Department for Transport

**APPLICATION FOR NON-MATERIAL CHANGES TO THE M25 JUNCTION 10/A3
WISLEY INTERCHANGE DEVELOPMENT CONSENT ORDER 2022 (S.I. 2022 NO.
549), AS CORRECTED BY THE M25 JUNCTION 10/A3 WISLEY INTERCHANGE
DEVELOPMENT CONSENT (CORRECTION) ORDER 2023 (S.I. 2023 NO. 46)**

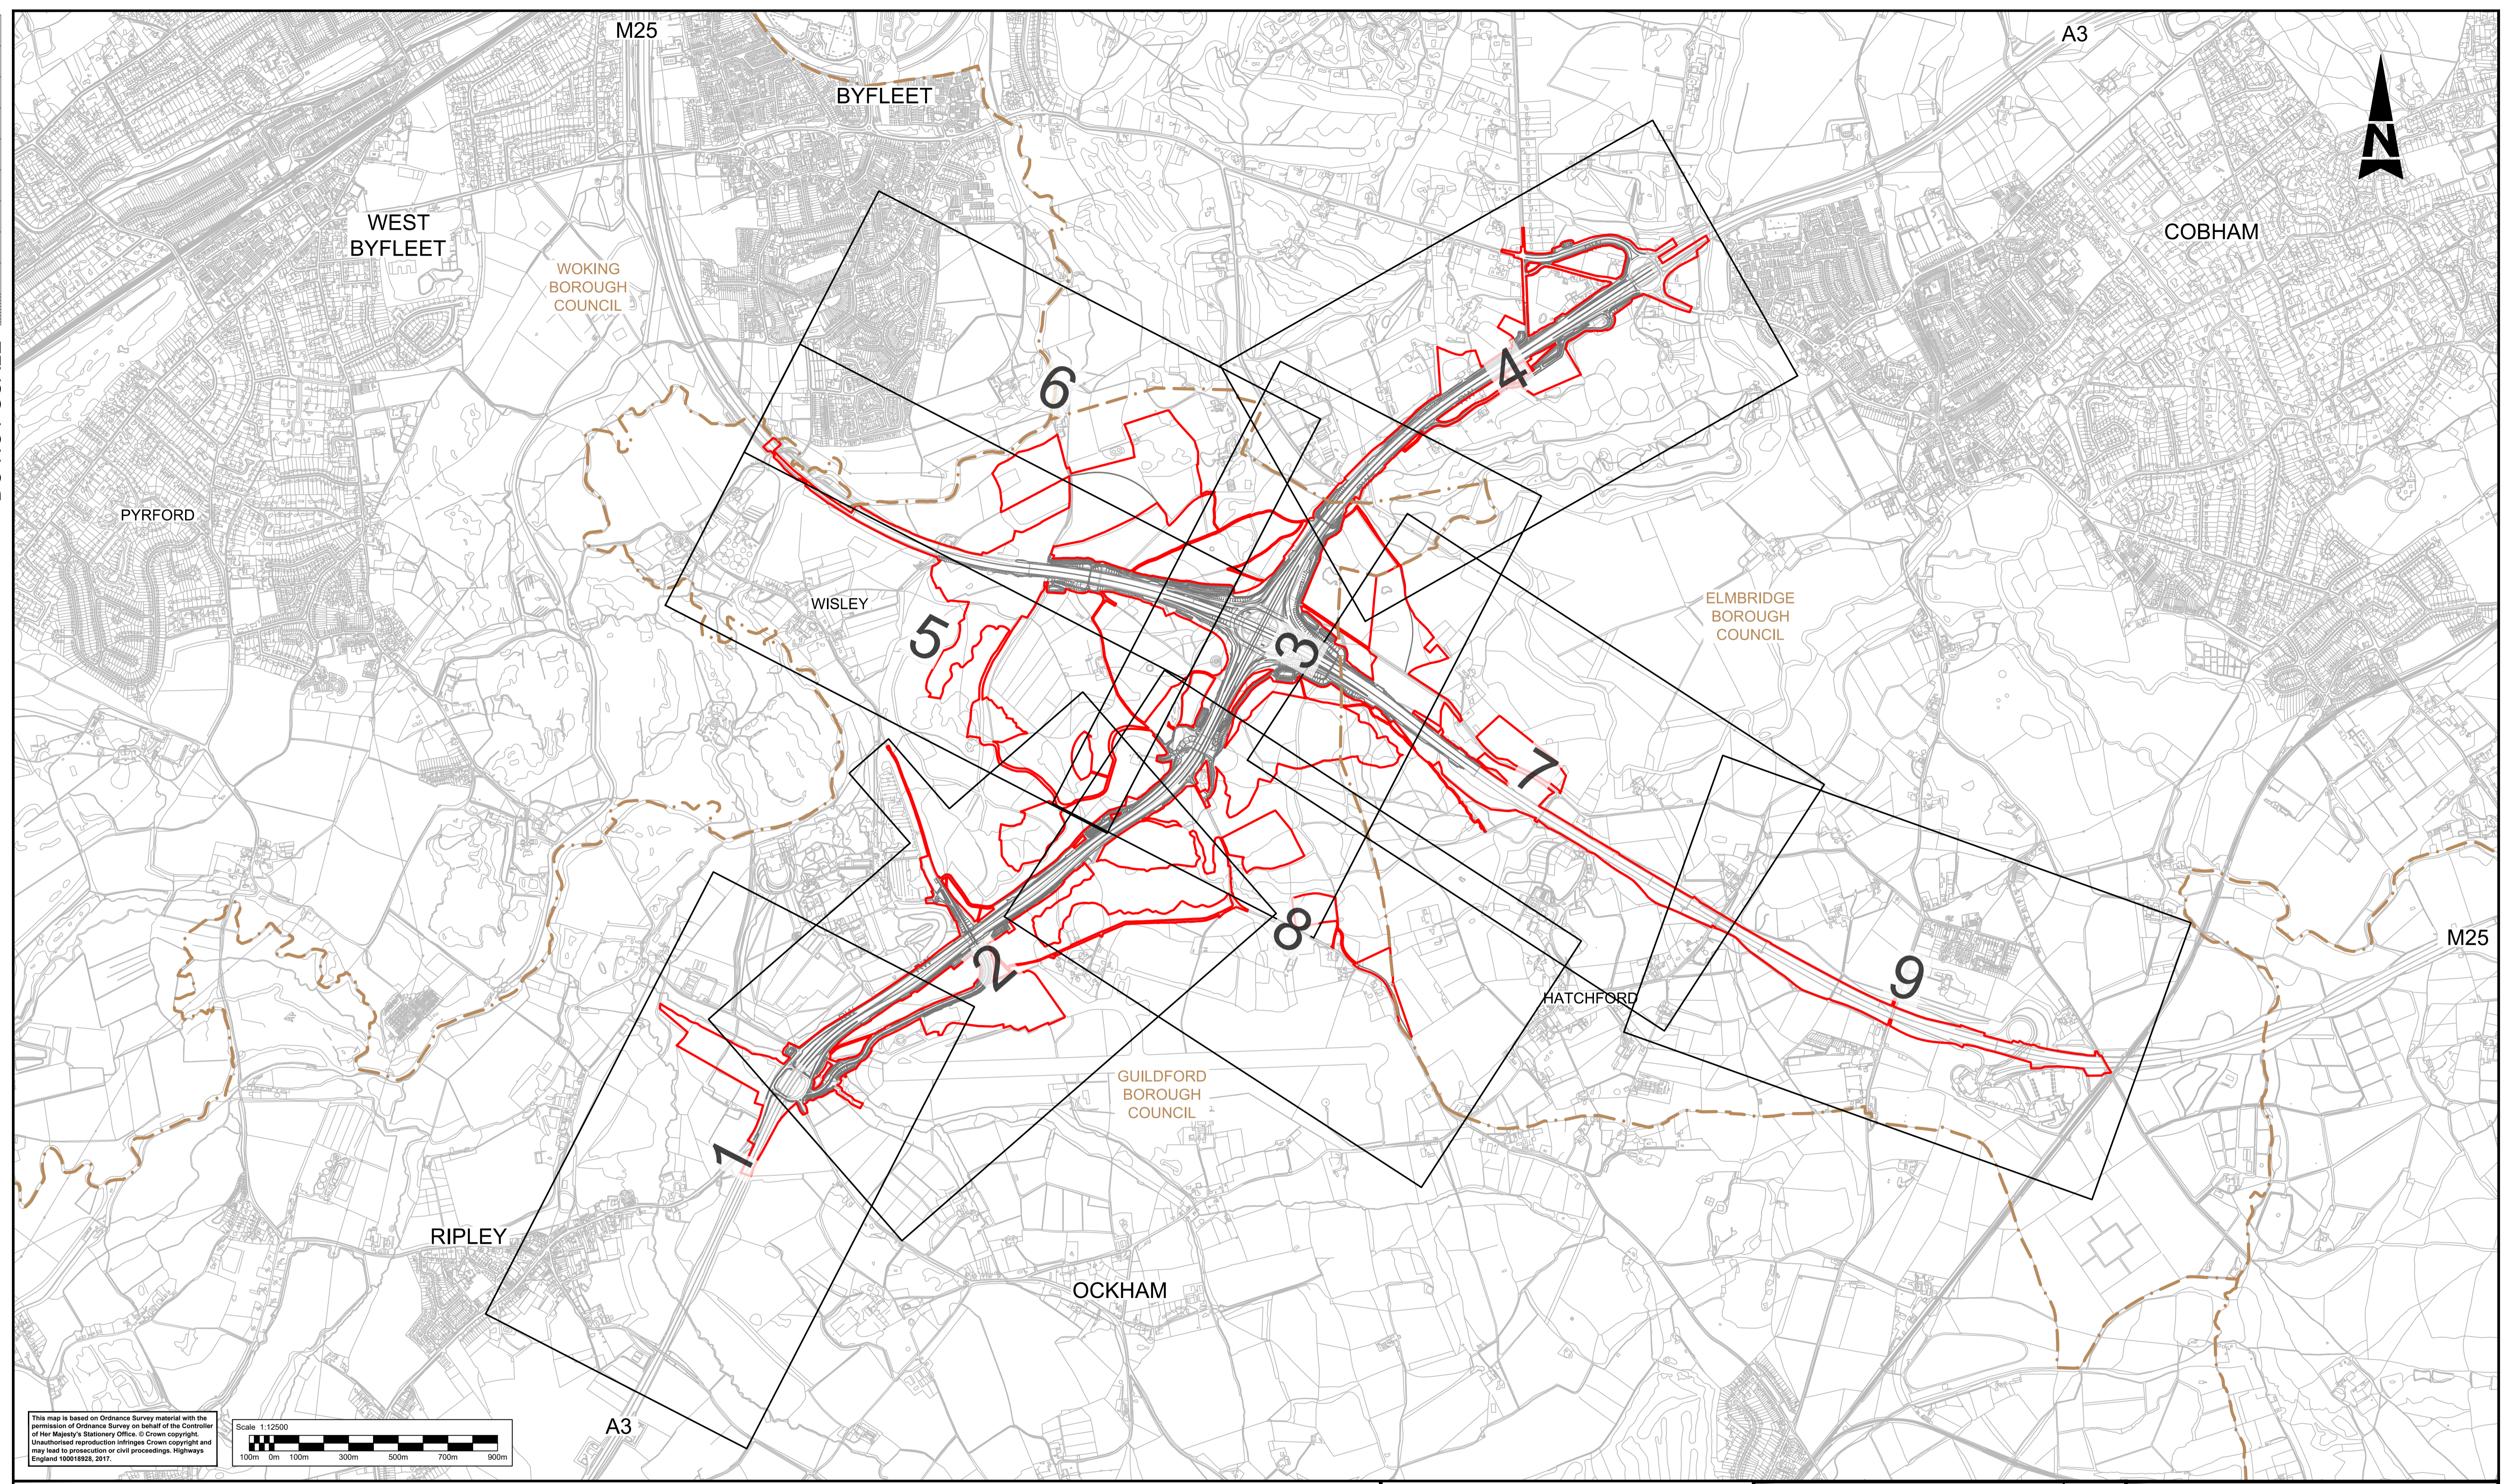
- Introduce variable speed limits on the M25 main carriageway and its slip roads at Junction 10. This will allow the safe and efficient operation of the road network by ensuring that the fixed speed limit provisions authorised by the Order, do not conflict with the variable speed limits for the M25 as prescribed under the [M25 Motorway \(Junctions 7 to 16\) \(Variable Speed Limits\) Regulations 2012](#);

- Update the relevant Speed Limits and Traffic Regulations Plans listed in Schedule 11 to the Order (sheets 3, 4, 5, 6, 7 and 9) to reflect the above changes.

Drawing Title: **SPEED LIMITS AND TRAFFIC REGULATIONS PLANS REGULATION 5(2)(o) SHEET 3 OF 9**

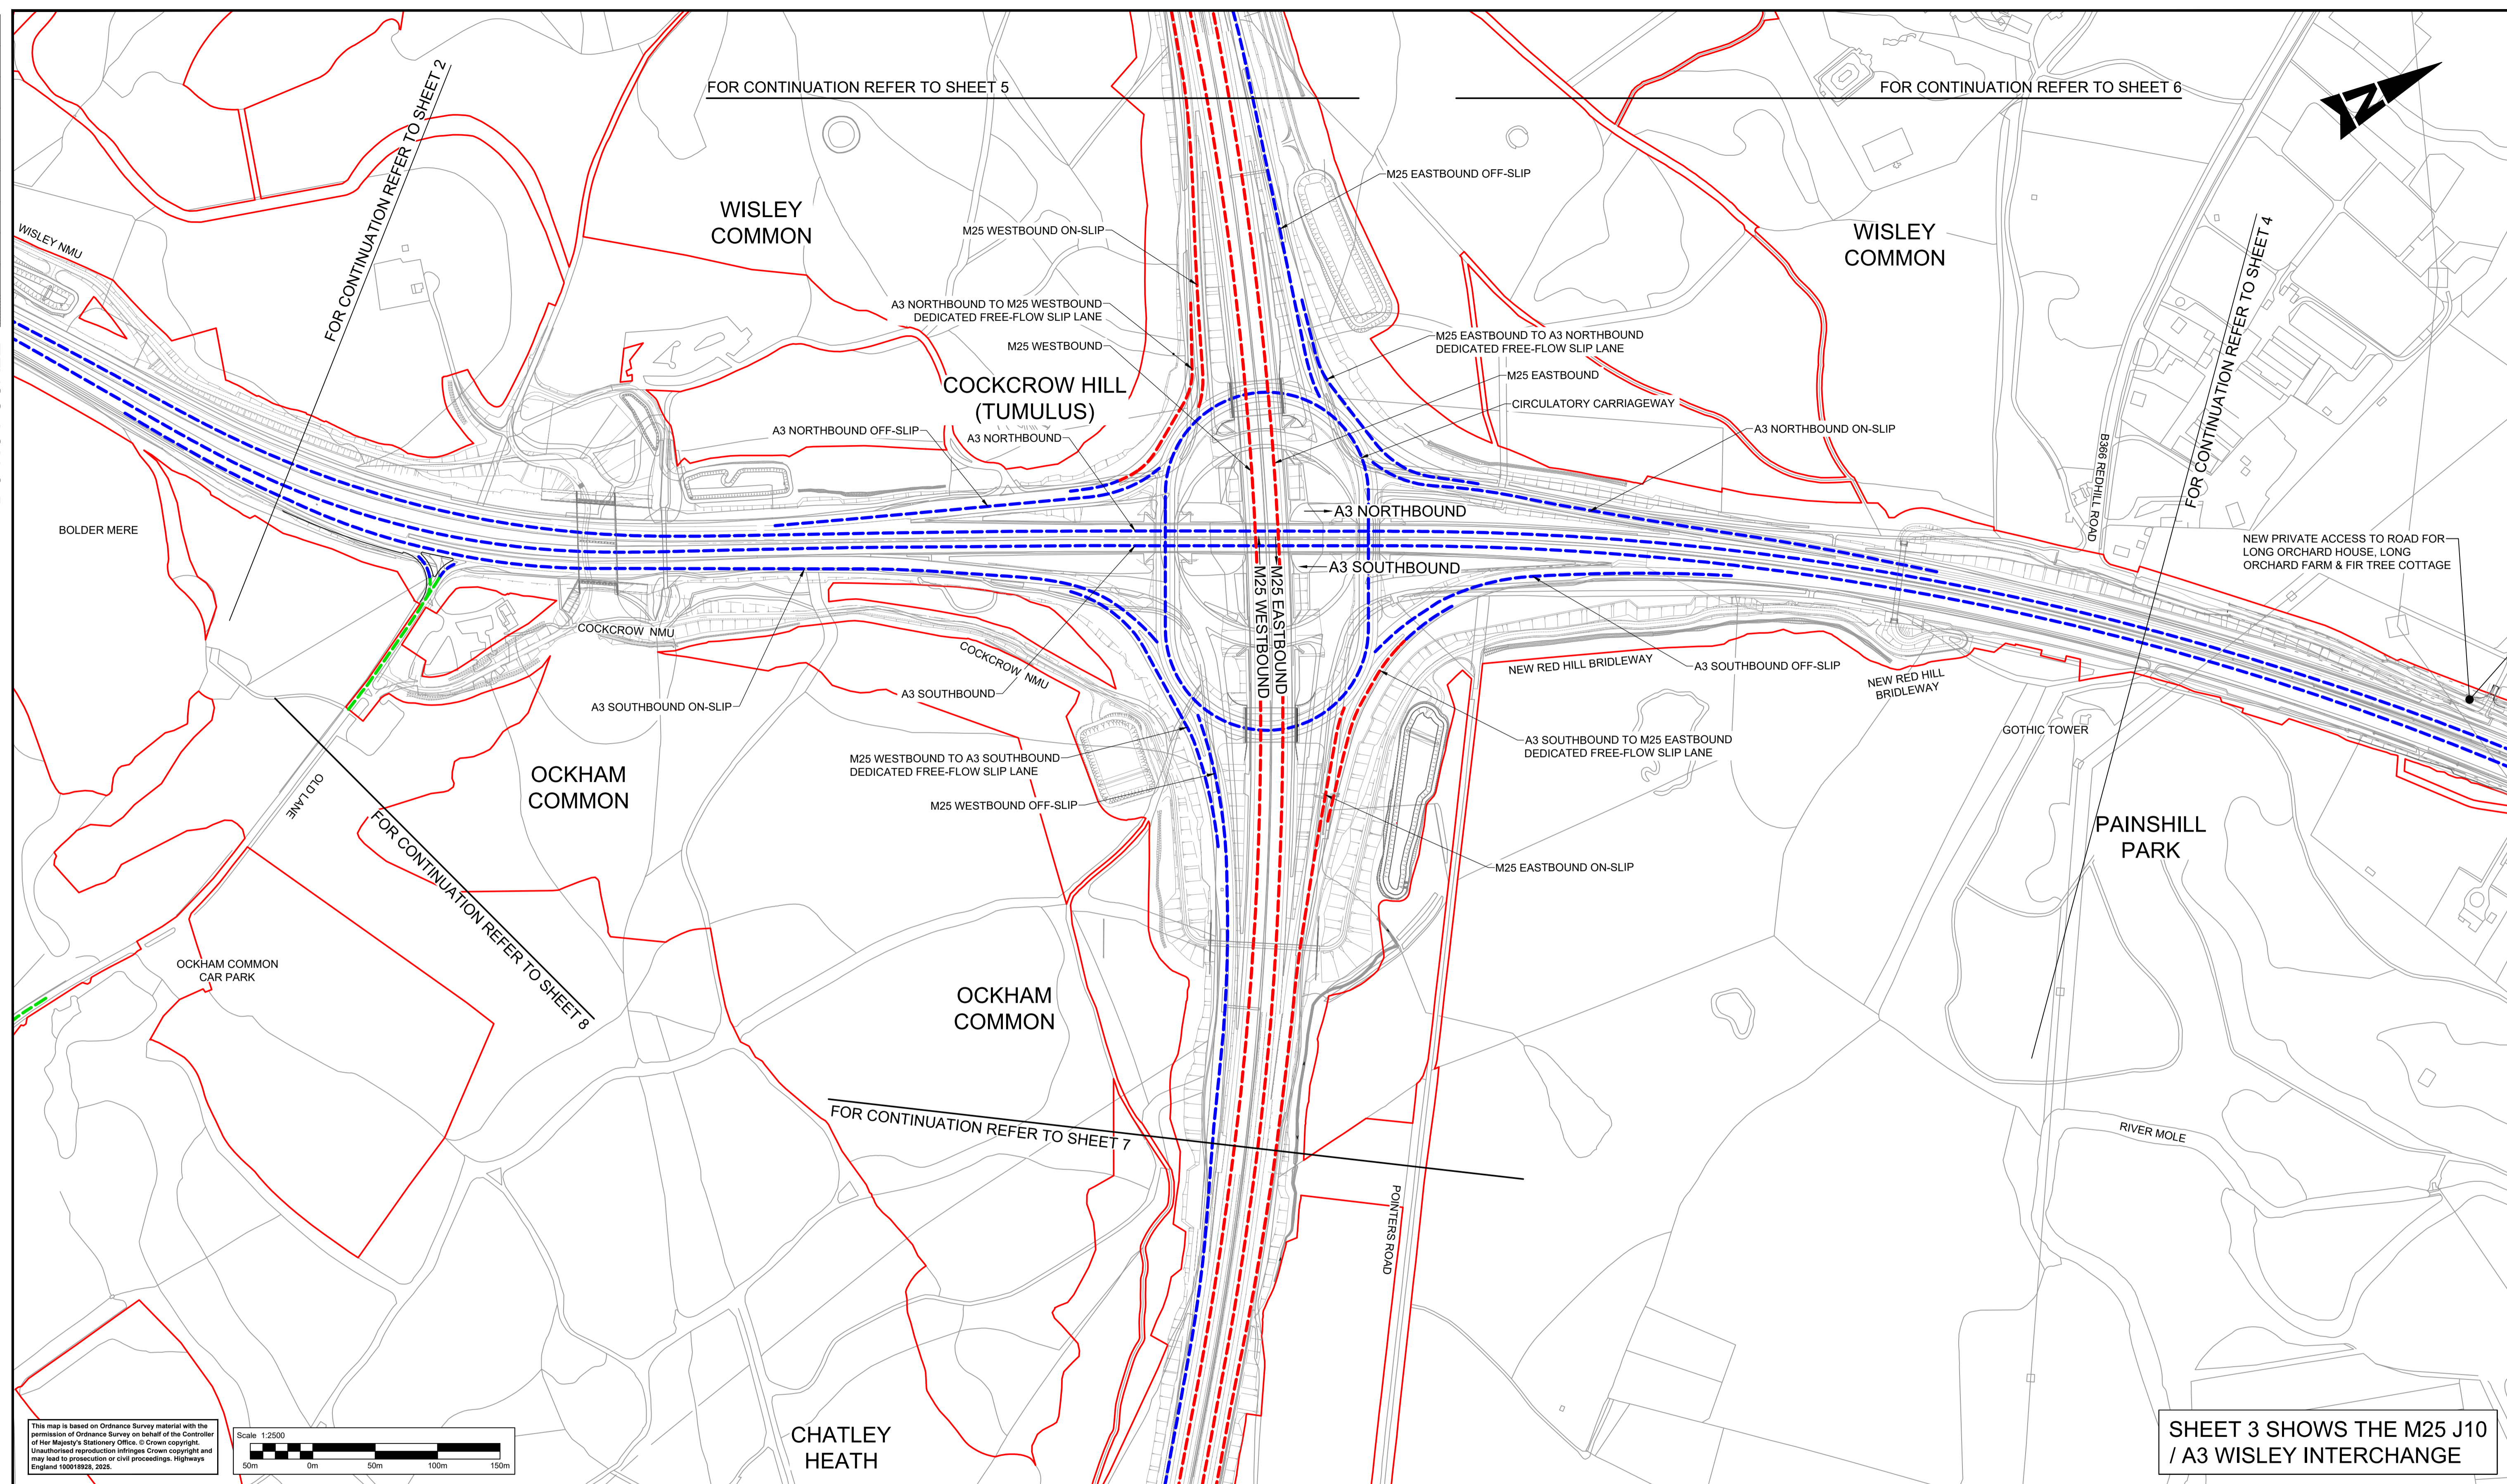
- Amend the Order to reflect that works to the A3 northbound to A245 westbound slip lane at Painshill junction (the “jet lane”) are no longer going ahead and are not included in the authorised Development, following a design change approved by the Secretary of State under requirement 5 of the Order on 28 February 2024. This change simply seeks to remove the road from the list of roads in Part 5 of Schedule 3 to the Order with prescribed speed limits; and
